SSD-13855453: Lot: Lot: 1 DP1022013, Lots: 1-3 DP1206485 and Lot: 22 DP866857, 1130 Gooloogong Road, Grenfell, Grenfell Poultry Breeding Farm

Thank you for referring concept design for the Basic Left (BAL) and Basic Right (BAR) Turn Treatments to TfNSW inviting comment from Transport for NSW (TfNSW).

AP02

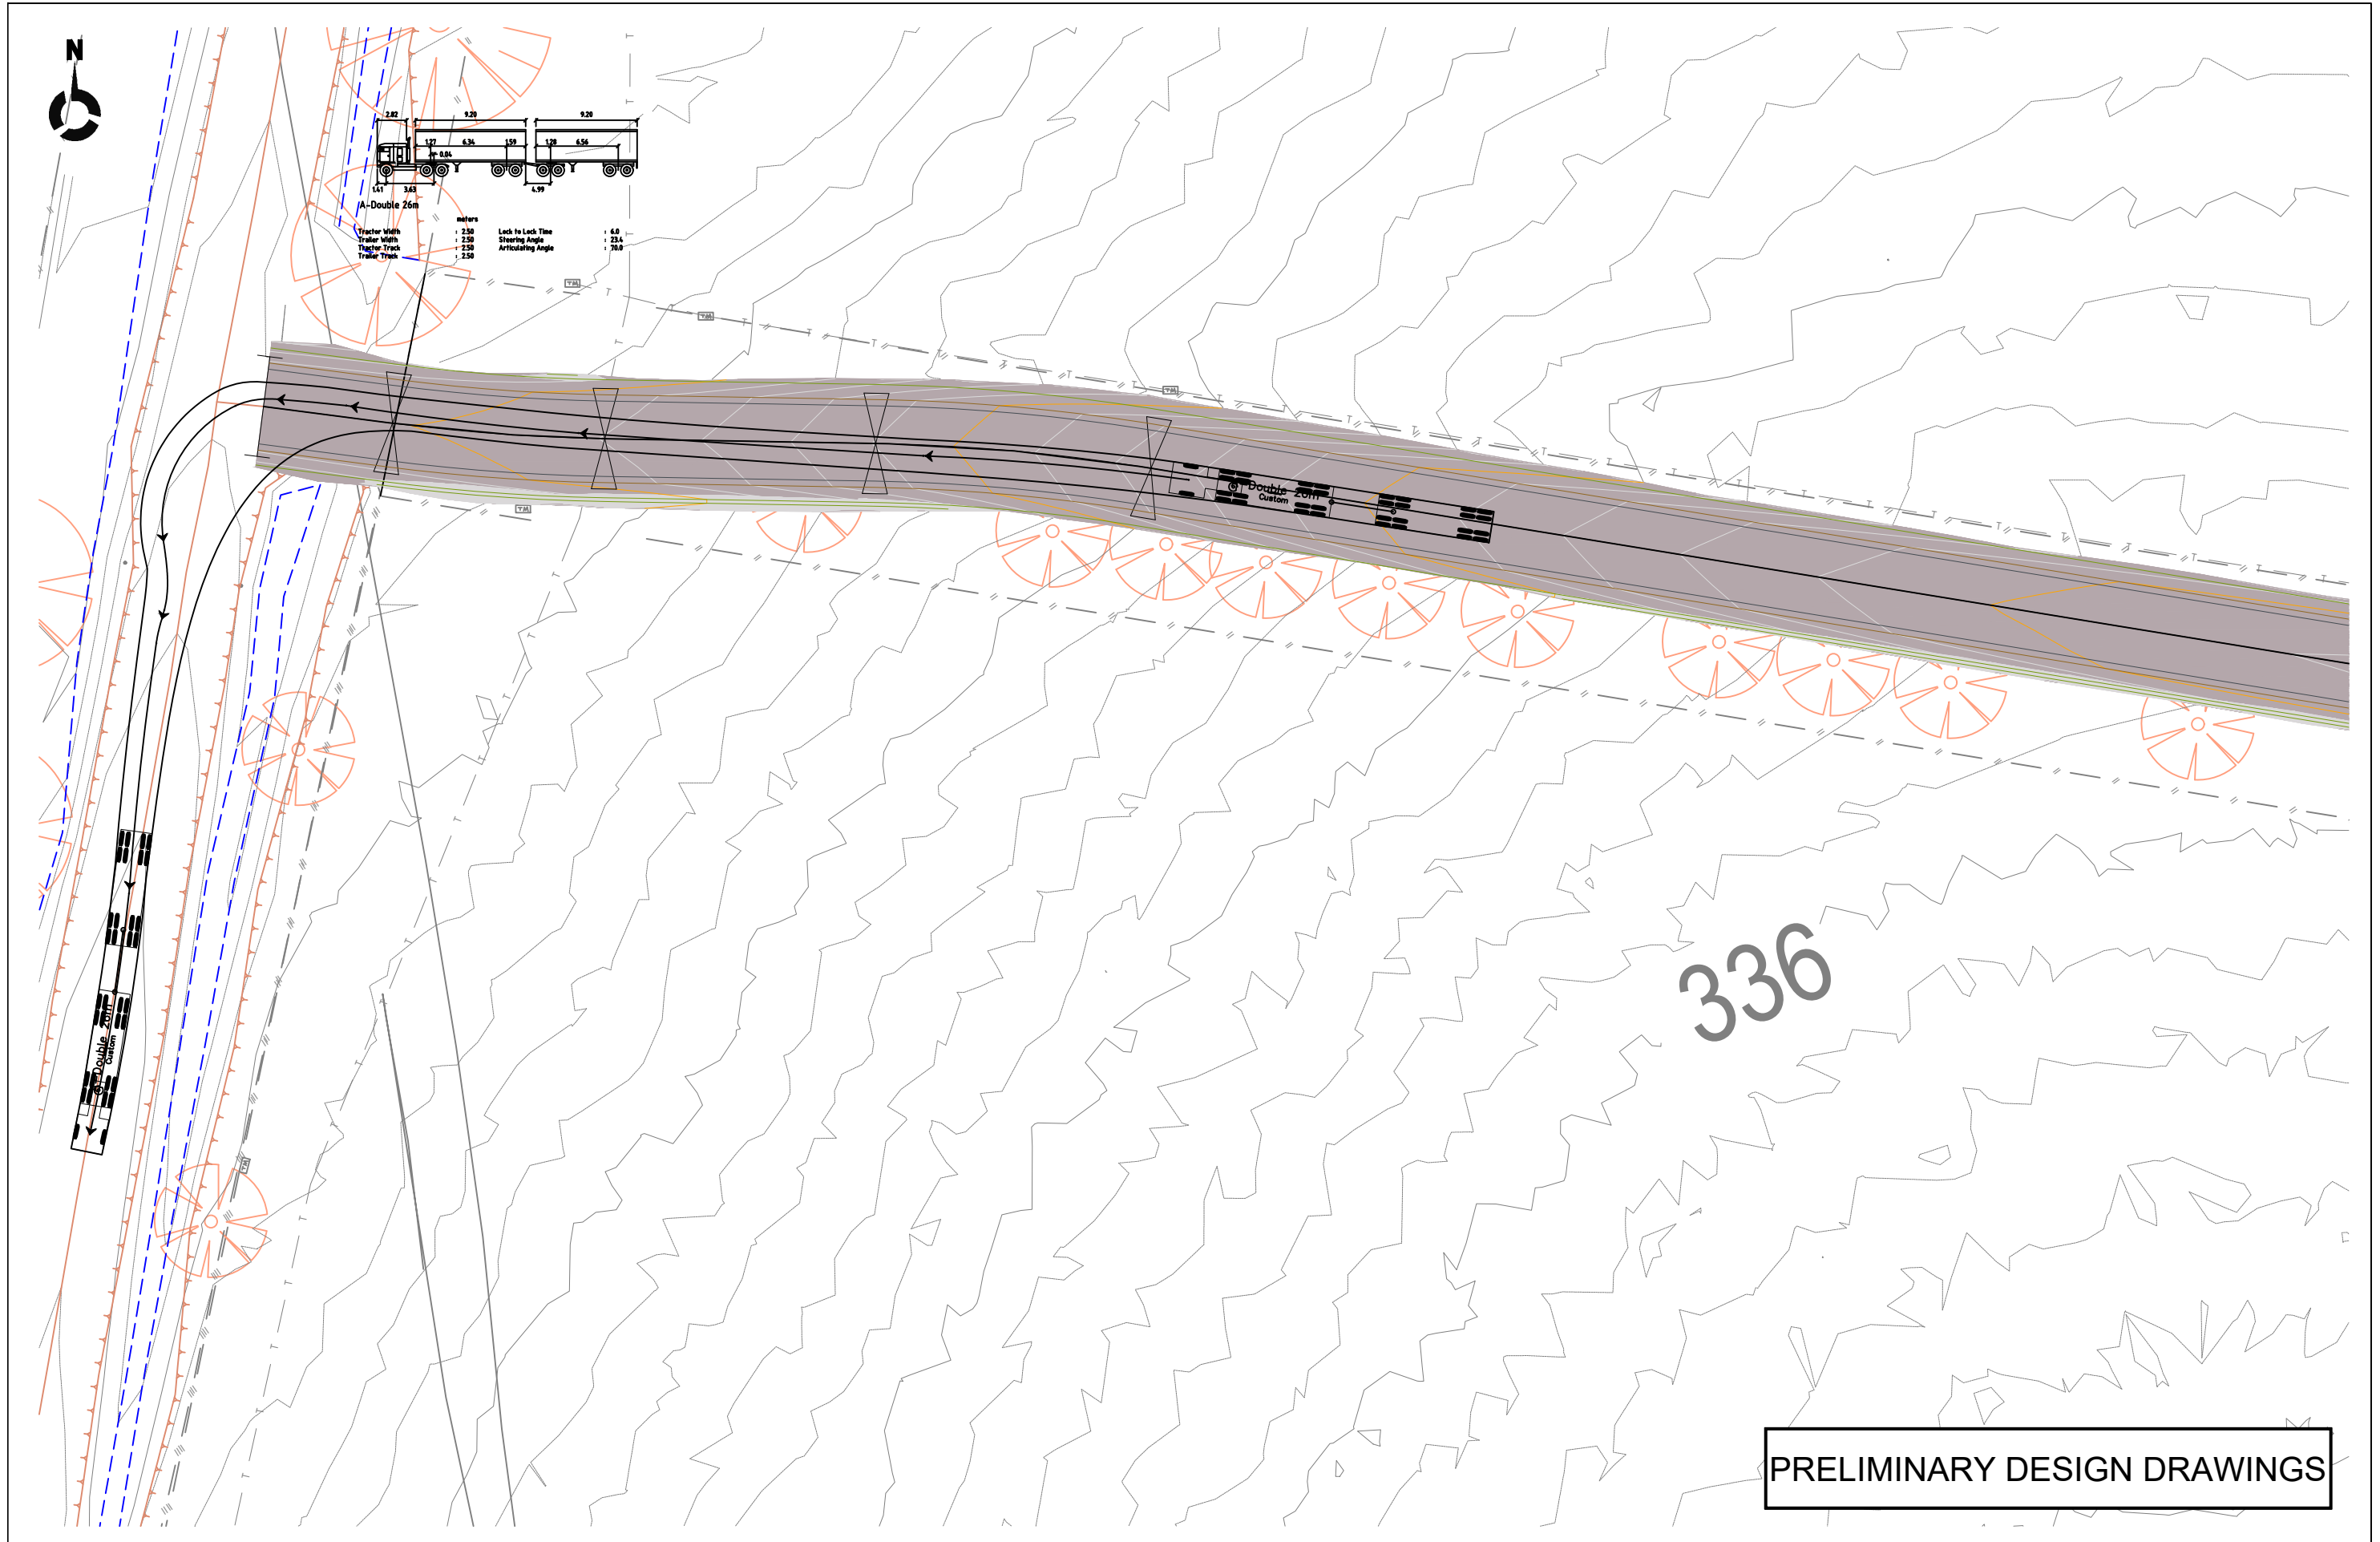
TfNSW's has reviewed the provided plan and is generally supportive of the proposed Basic Left (BAL) and Basic Right (BAR) as the warranted turn treatment for the intersection upgrade at Gooloogong Road however, the provided swept path diagrams demonstrate the proposed design results in turning vehicles deviating from the correct lane in order to achieve the turn movements in an unsafe manner.

DRAWING TITLE	EXIT TO GOOLOOGONG SWEEP PATH
CLIENT	BAIADA
PROJECT	GRENFELL FARMS
LOCATION	1130 GOOLOOGONG ROAD, GRENFELL, NSW

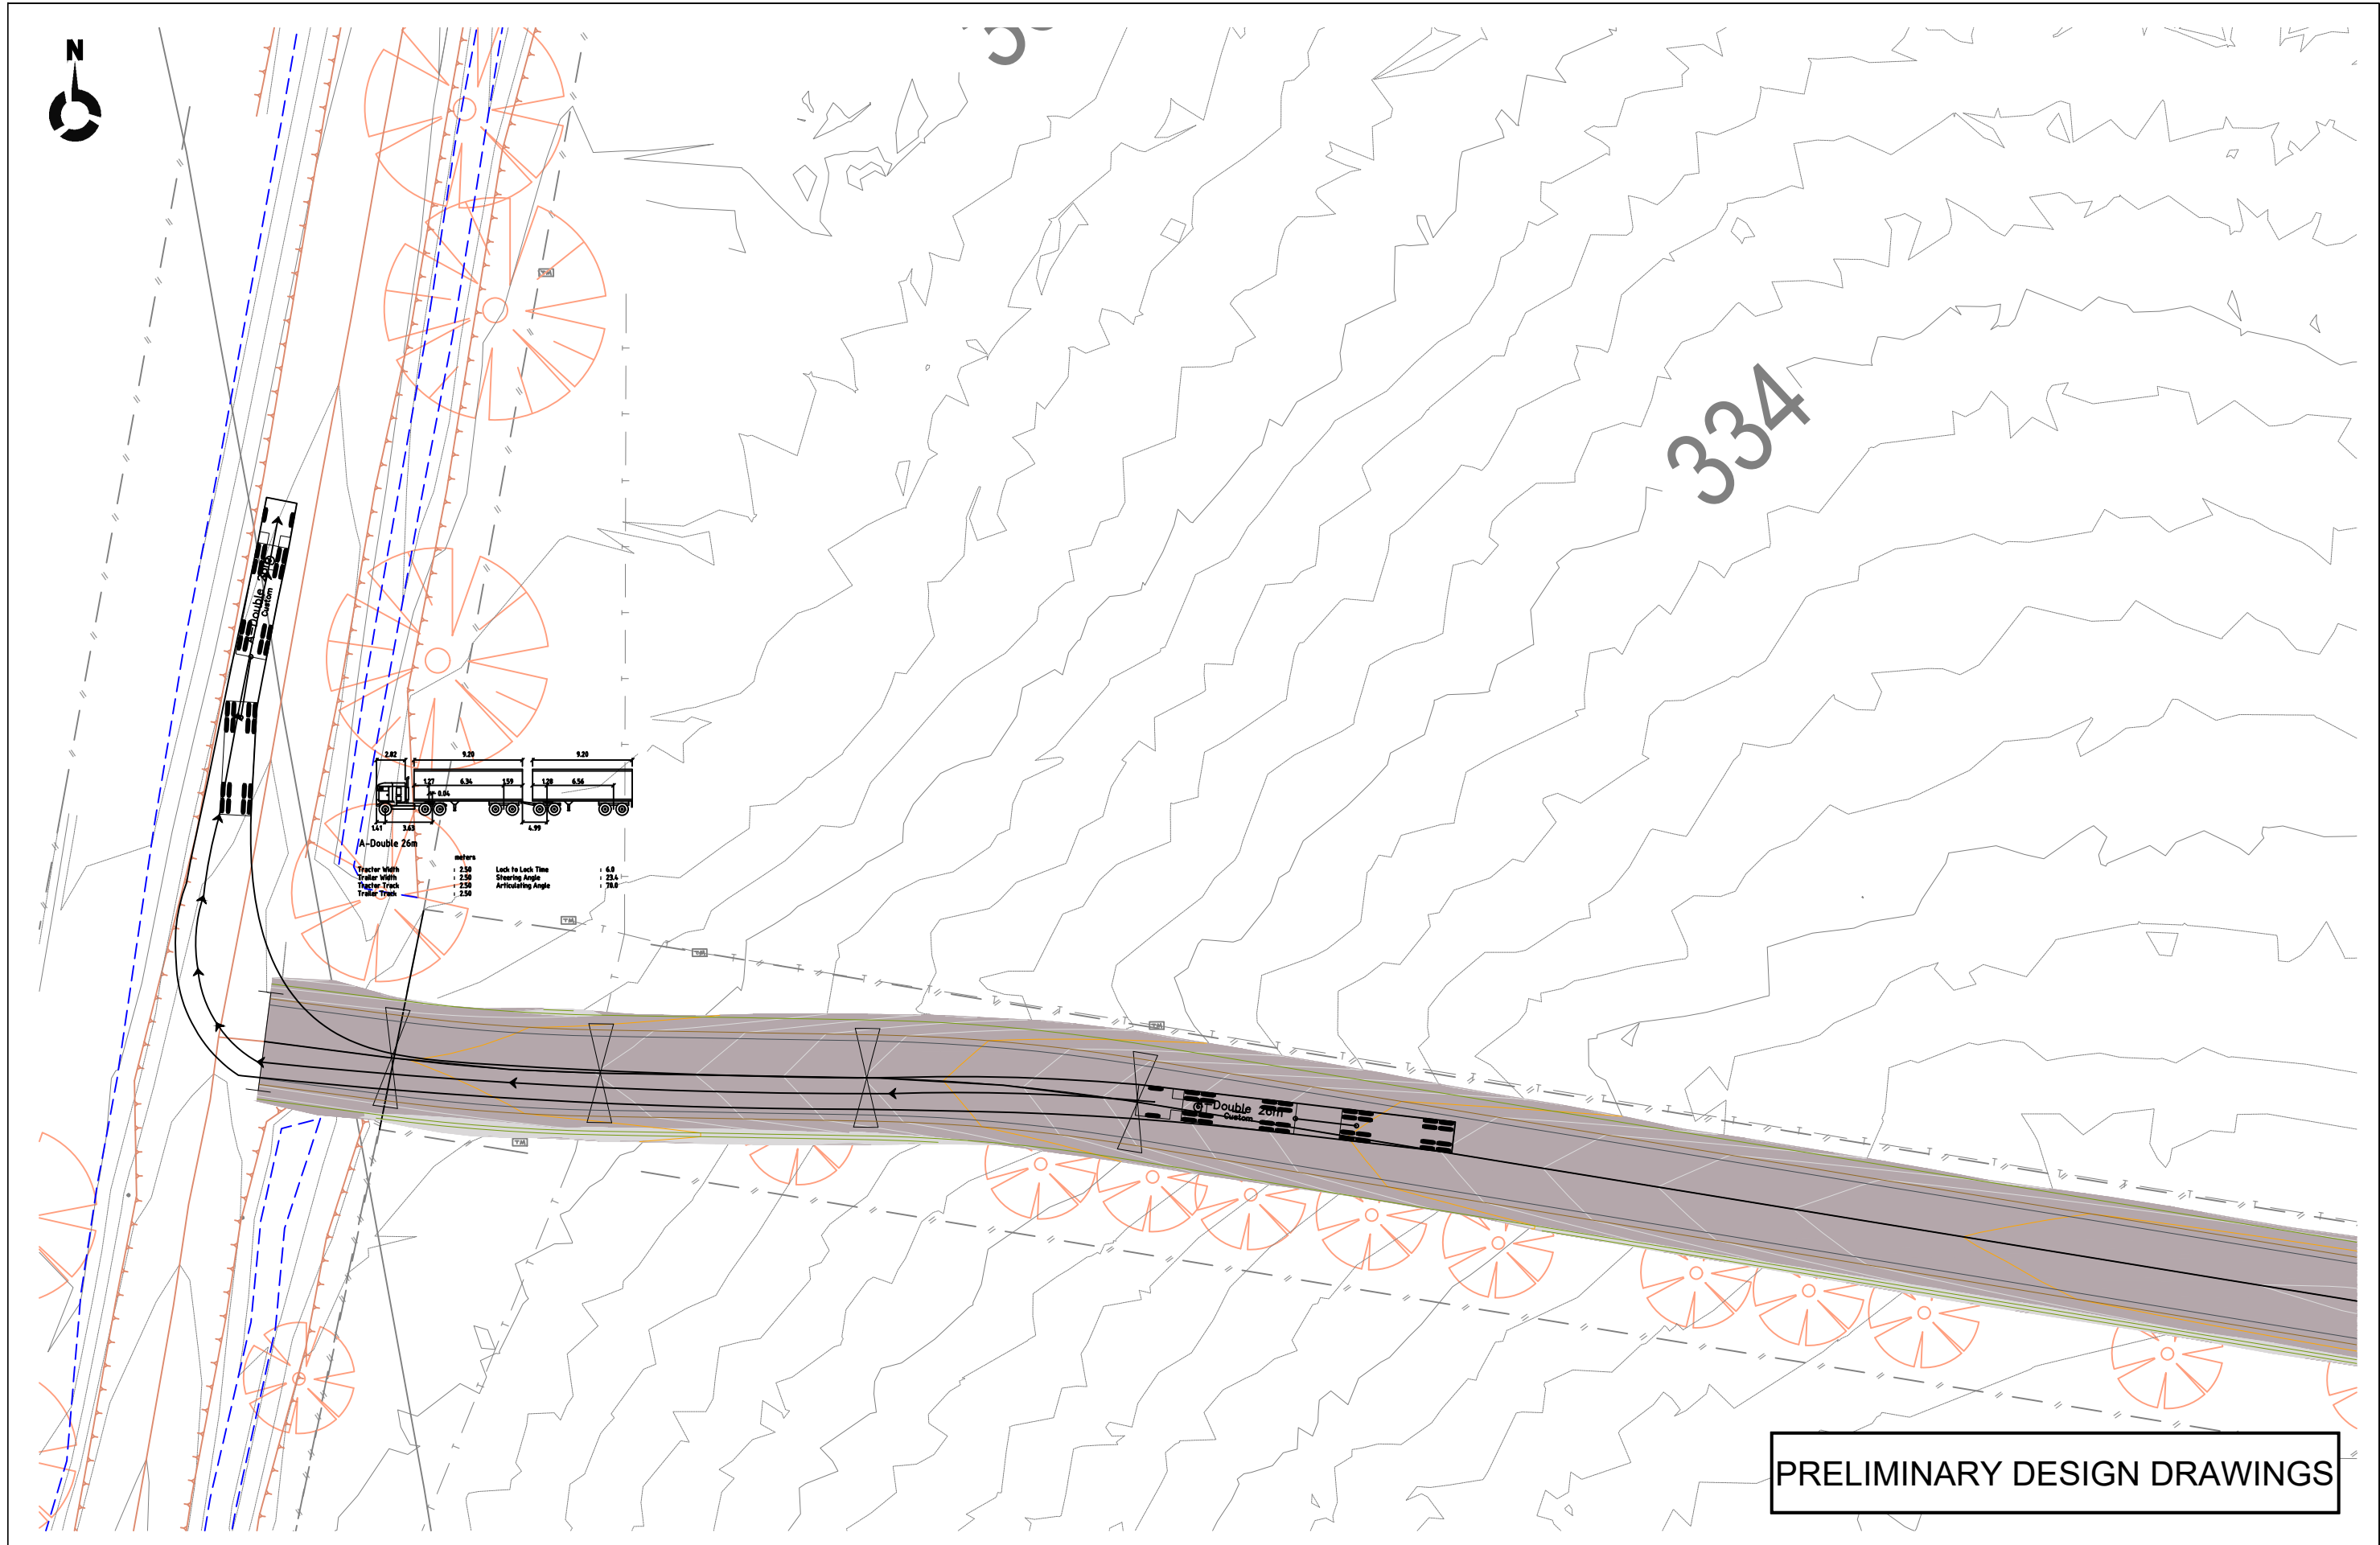
- The vehicles do not cross to the opposing traffic lane to effect the turn in or out of the access driveway.
- The vehicles do not encroach on the BAR to achieve the right turn in.
